DELEGATED HOUSEHOLDER DECISION

Item No.	Report of the Head of Planning, Sport and Green Spaces	
Address	58 ROYAL LANE YIEWSLEY	
Development:	Part first floor rear extension and alteration of existing single storey side roof from flat to pitched	
LBH Ref Nos:	45648/APP/2014/857	
Drawing Nos:	p-pp-pe5 58-p-eg 58-p-ef 58-p-pg4 58-p-pf4 Block Plan (1:500) Location Plan (1:1250) ee-3	
Date Plans Received:	12/03/2014	Date(s) of Amendment(s):
Date Application Valid:	28/03/2014

PLANNING
Andrew Alexander Vorobiev
58 Royal Lane, West Drayton,
UB7 8DN
Scale – 1:50 @ A3
PROPOSED FIRST FLOOR
11/03/2014
Drawing No: 58-P-PF4

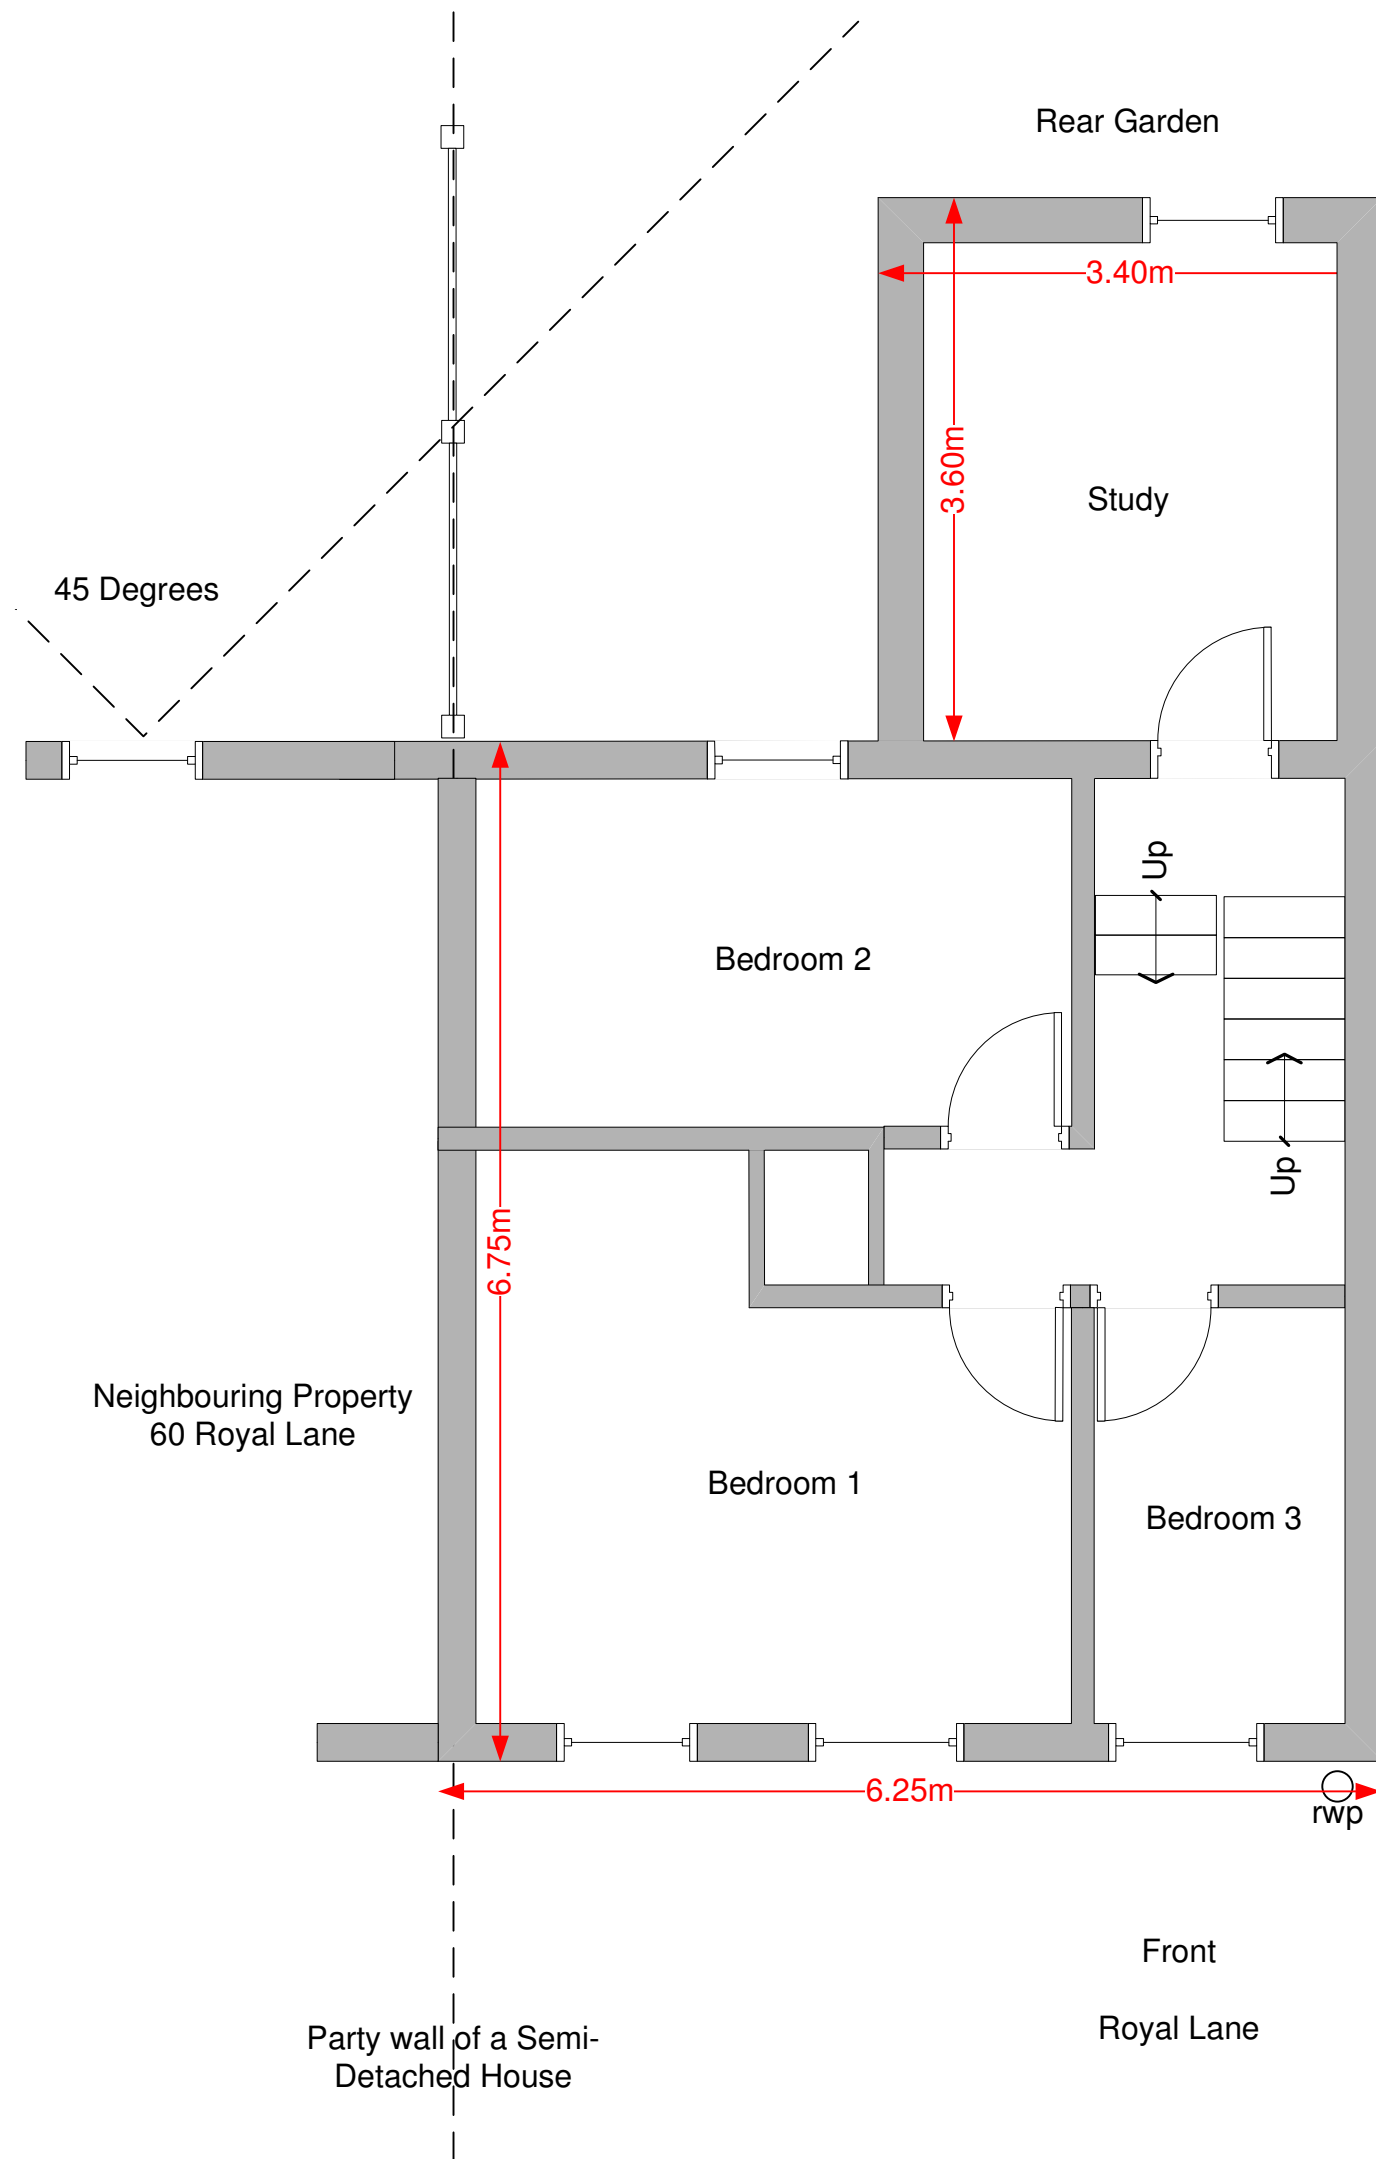
The scheme must be considered against relevant policy and HDAS: Residential Extensions guidance. In terms of the first floor rear extension HDAS: Residential Extensions paragraph 6.4 states that any two storey rear extension should project no more than 3.6m for a semi-detached property, provided that it does not extend beyond a 45 degree line of site taken from the nearest of the first floor windows of any room of the neighbouring property. The proposed two storey rear extension would comply with this guidance as it is 3.6m in depth and sits outside the 45 degree line of site from the closest dwelling's first floor windows. HDAS states that such an extension to a house with a pitched roof should also be pitched (and set down 0.5m from the ridge line). The proposed development has been amended to incorporate a pitched roof, however the design of the roof is considered unacceptable. This is in particular regard to the way it connects with the existing dormer and would therefore be an alien and incongruous architectural element. As such the proposed first floor rear extension is contrary to Policies BE13, BE15 and BE19 of the Hillingdon Local Plan (November 2012).

The proposed first floor rear extension, by virtue of its roof design, would result in an

incongruous addition which would be detrimental to the architectural composition of the existing building and would harm the character and appearance of the wider area. The proposal would therefore be contrary to Policy BE1 of the Hillingdon Local Plan: Part One - Strategic Policies (November 2012), Policies BE13, BE15 and BE19 of the Hillingdon Local Plan: Part Two - Saved UDP Policies (November 2012) and the adopted Supplementary Planning Document HDAS: Residential Extensions.

Drawing Number P-PP-PE5

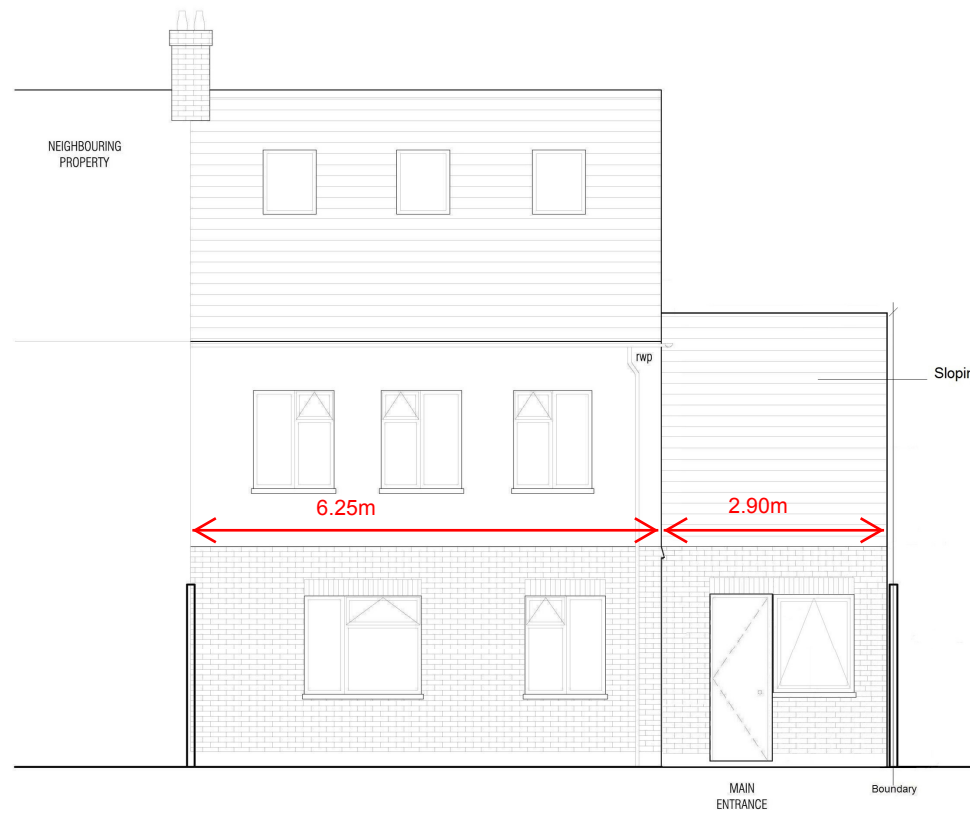
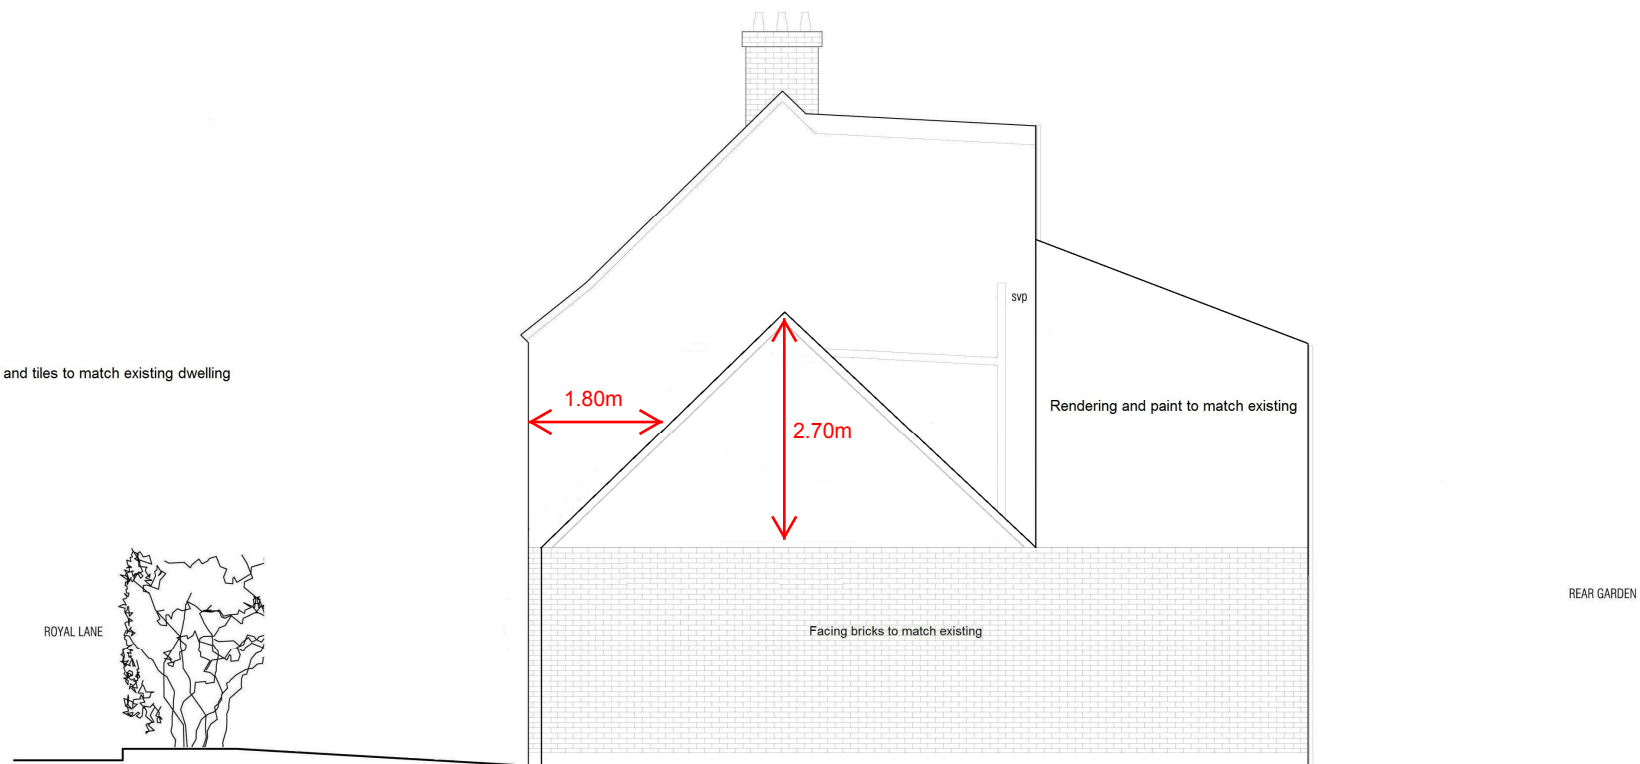
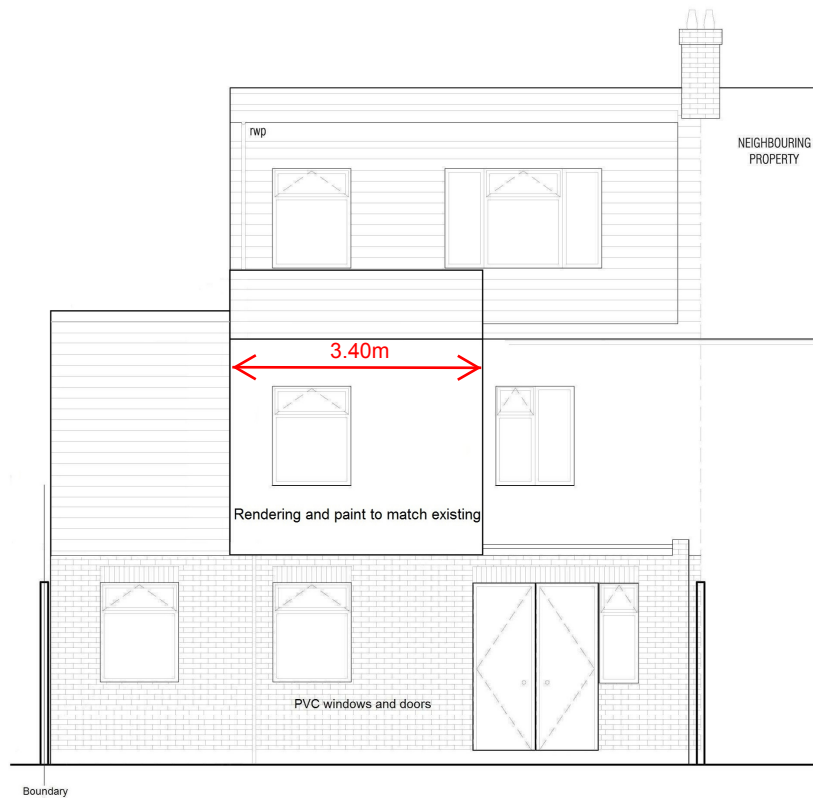
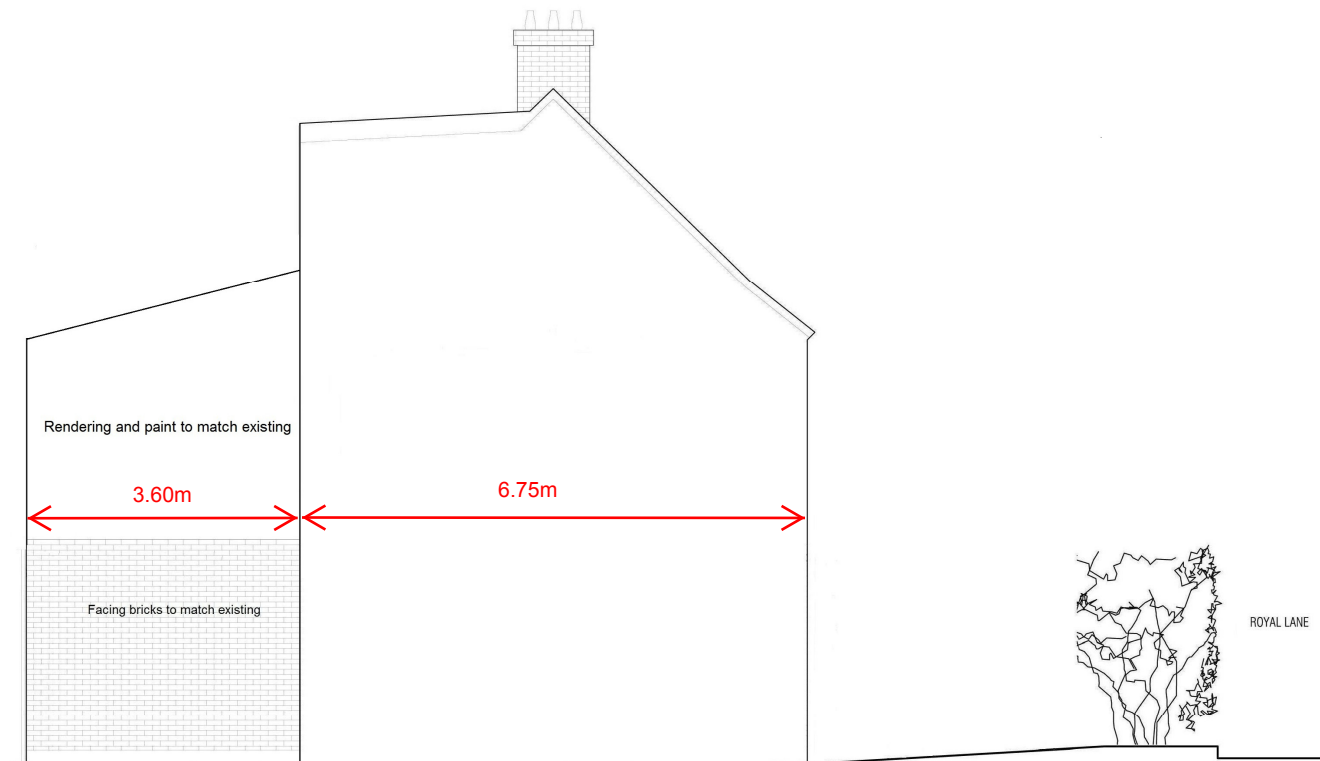
In terms of the alterations to the roof of the single storey side extension, HDAS: Residential Extensions paragraph 4.2 states that a range of pitched/hipped roof types may be acceptable but the roof should not exceed 3.4m at its highest point. the proposed roof as submitted has a maximum height of 6.0m, significantly greater than the maximum recommended by HDAS. The amended roof design is therefore deemed contrary to Policies BE13, BE15 and BE19 of the Hillingdon Local Plan (November 2012) and HDAS: Residential Extensions guidance.

The proposed roof above the existing ground floor side extension, by virtue of its size, scale, bulk and design, would result in an incongruous addition which would be detrimental to the architectural composition of the existing building, the visual amenity of the street scene and would harm the character and appearance of the wider area. The proposal would therefore be contrary to Policy BE1 of the Hillingdon Local Plan: Part One - Strategic Policies (November 2012), Policies BE13, BE15 and BE19 of the Hillingdon Local Plan: Part Two - Saved UDP Policies (November 2012) and the adopted Supplementary Planning Document HDAS: Residential Extensions.
